Objection for Planning Application 2024/62/90947 12 > 7 houses (Yorkshire Country Properties)

I am the neighbouring land owner which is part of allocation H203

2020/62/93358/E Land east of, Abbey Road, Shepley, Huddersfield, HD8 8FG

Section 1 - 1  
1:200

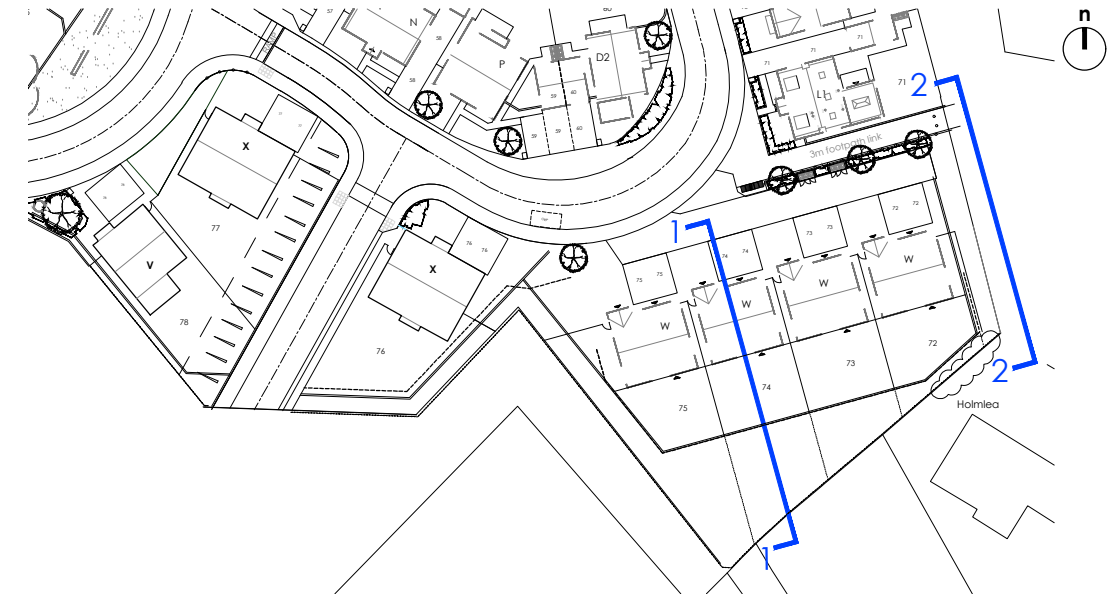
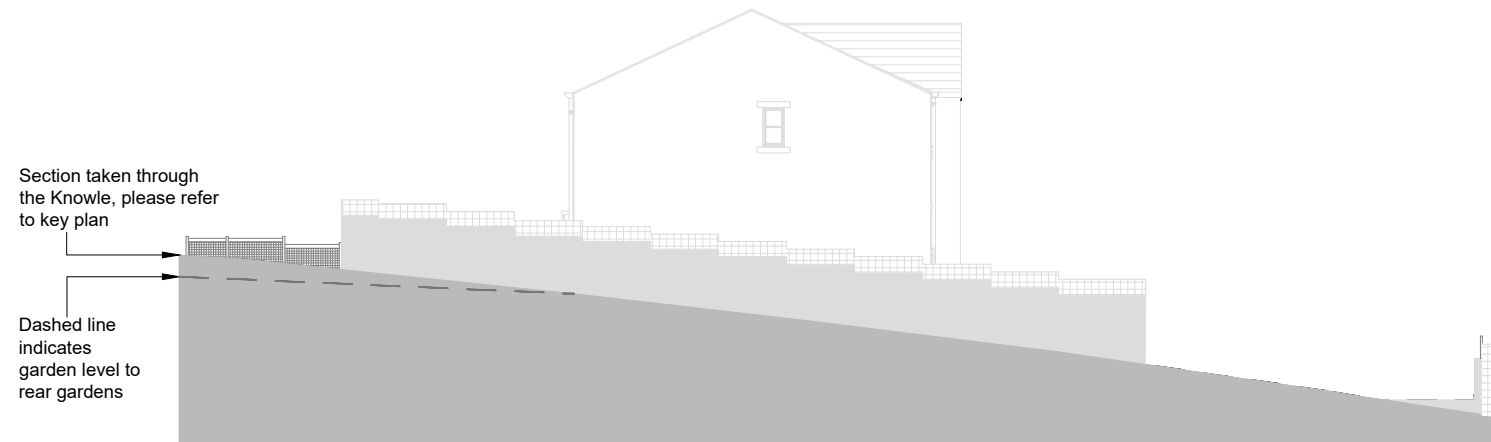
The applicant has not demonstrated any plans that make any attempt to achieve the levels required for this vehicular access.

I suggest that this Planning Application should be rejected until workable plans have been submitted to achieve an Adoptable Vehicular Access to the adjacent land.

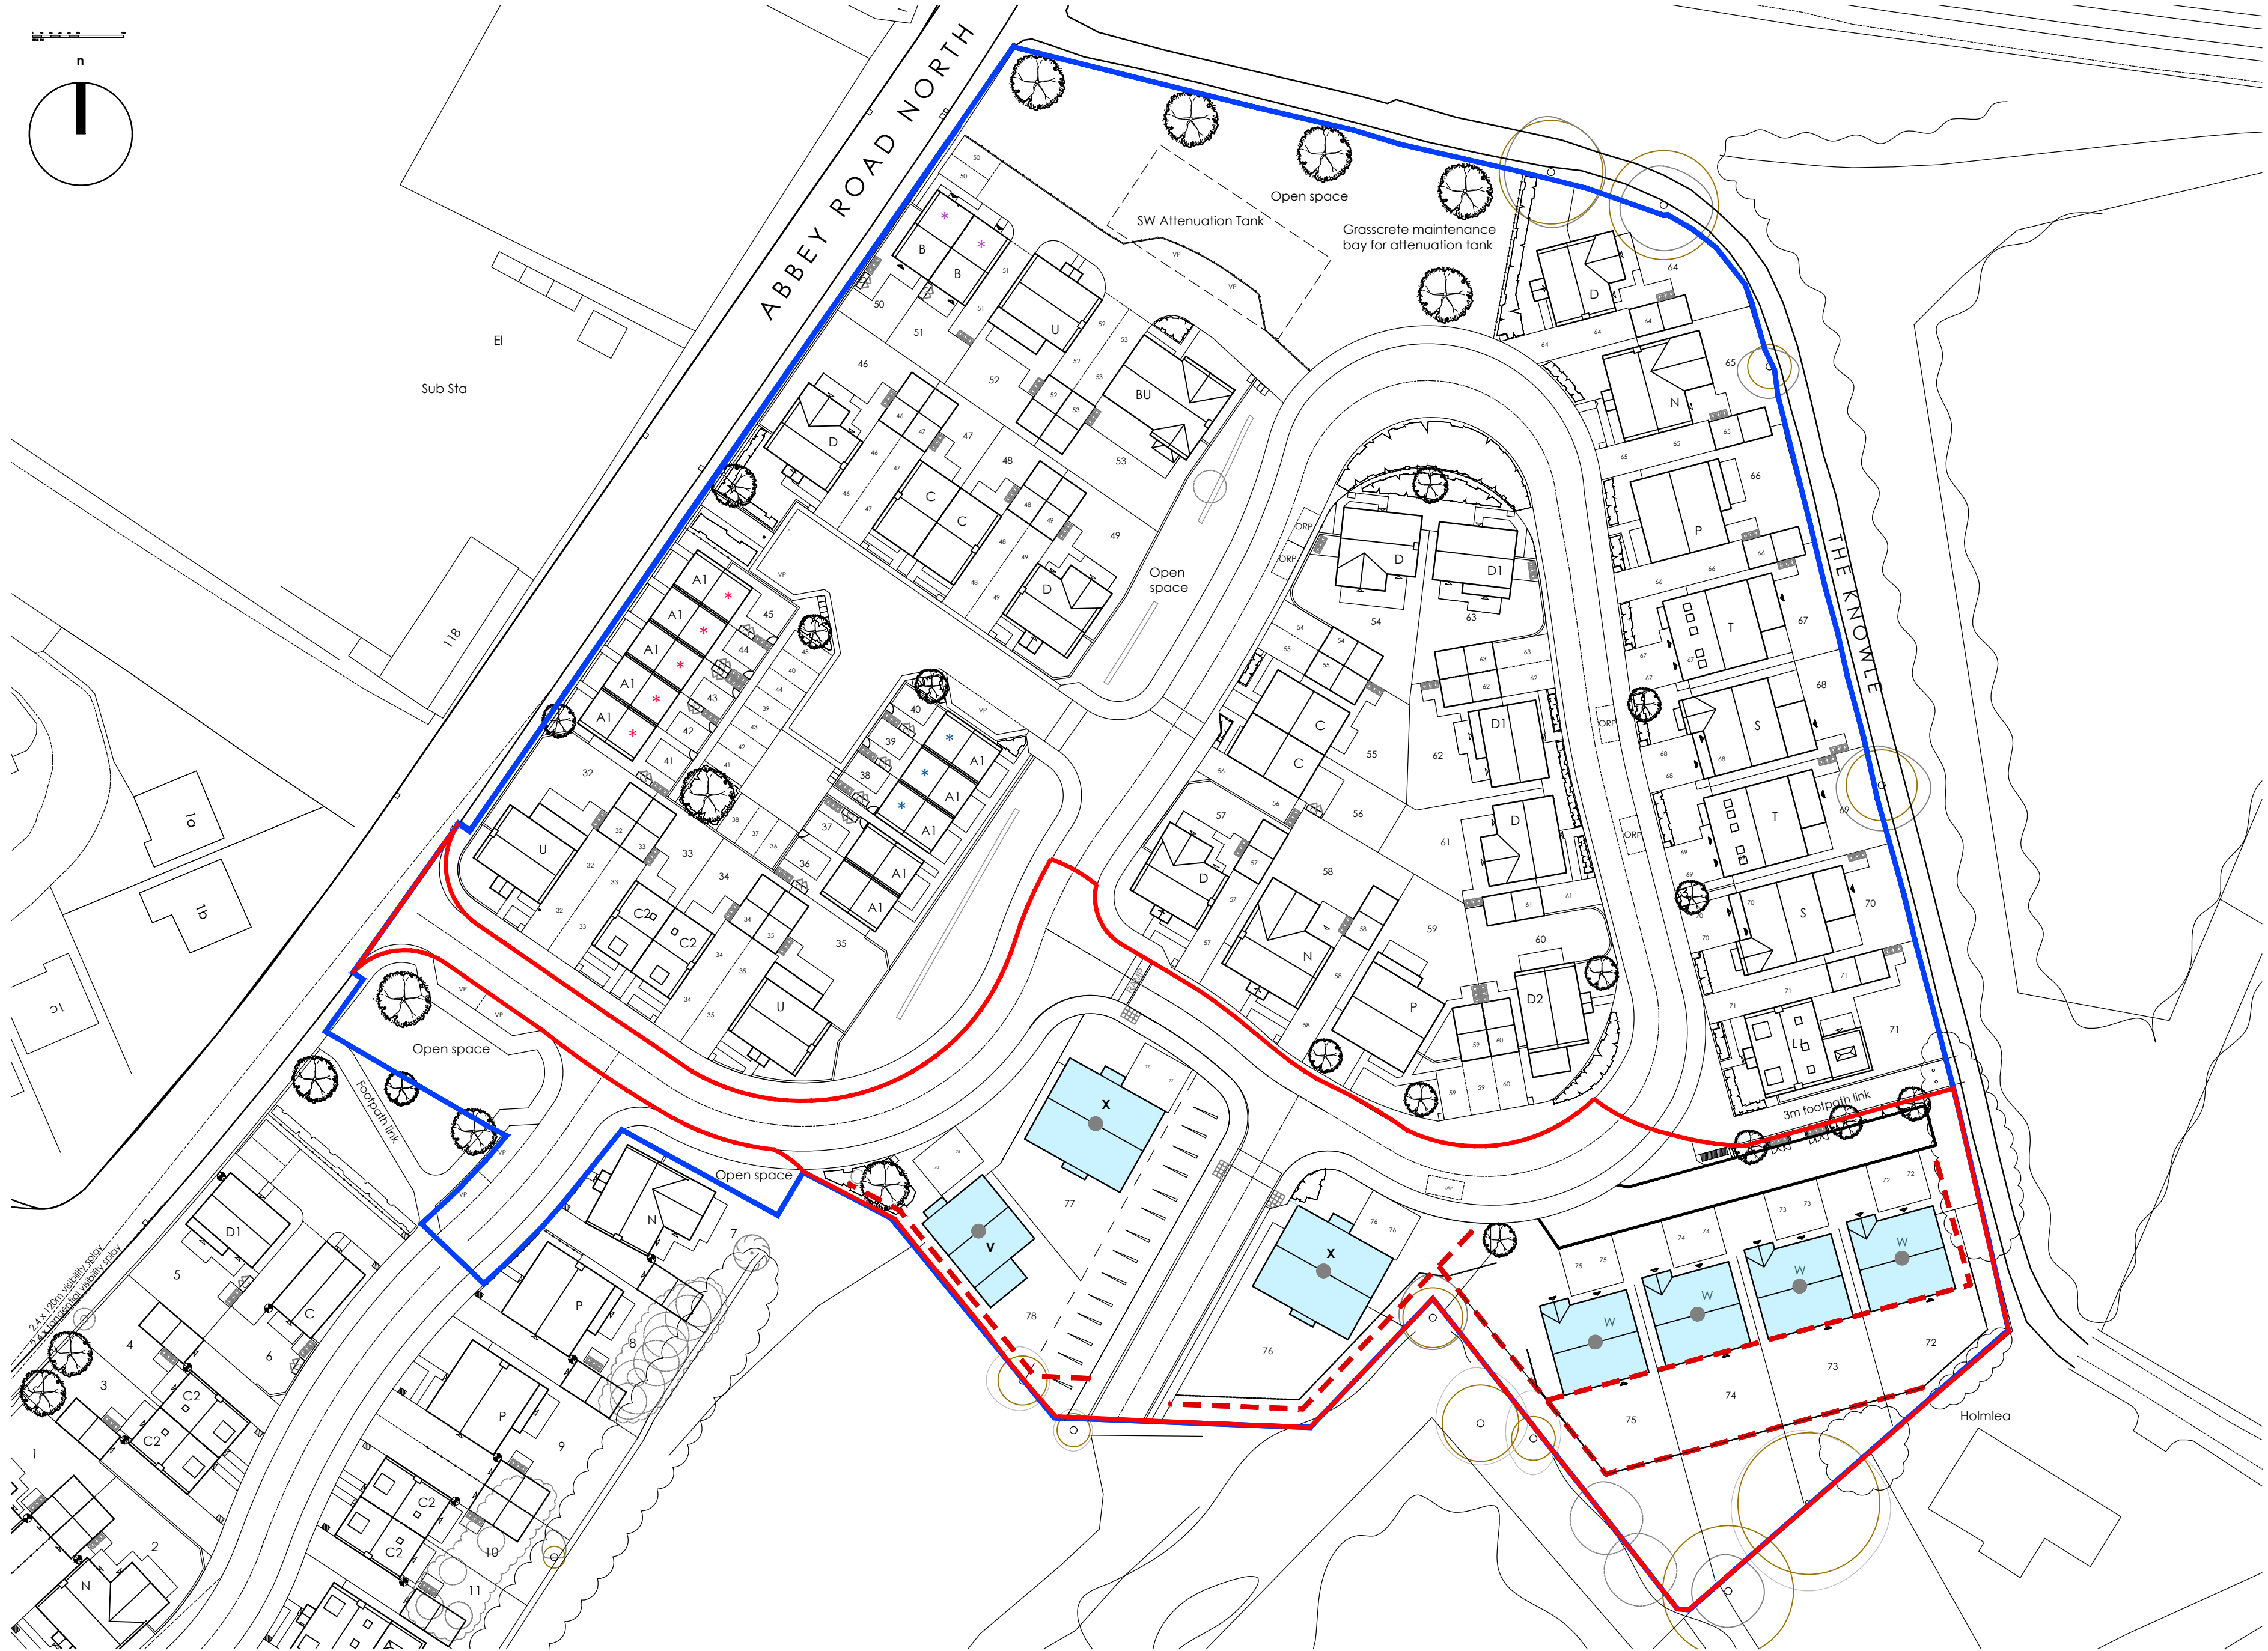
The plans show Retaining Walls some 2.4M high on the immediate boundary of my adjacent land.

We suggest that the application should be rejected until a safe and achievable plan is submitted.

The original planning approval for this site was “Natural” stone and “Natural” slate roof. We would prefer to stick to the original agreement considering that this would blend with the neighbouring properties.
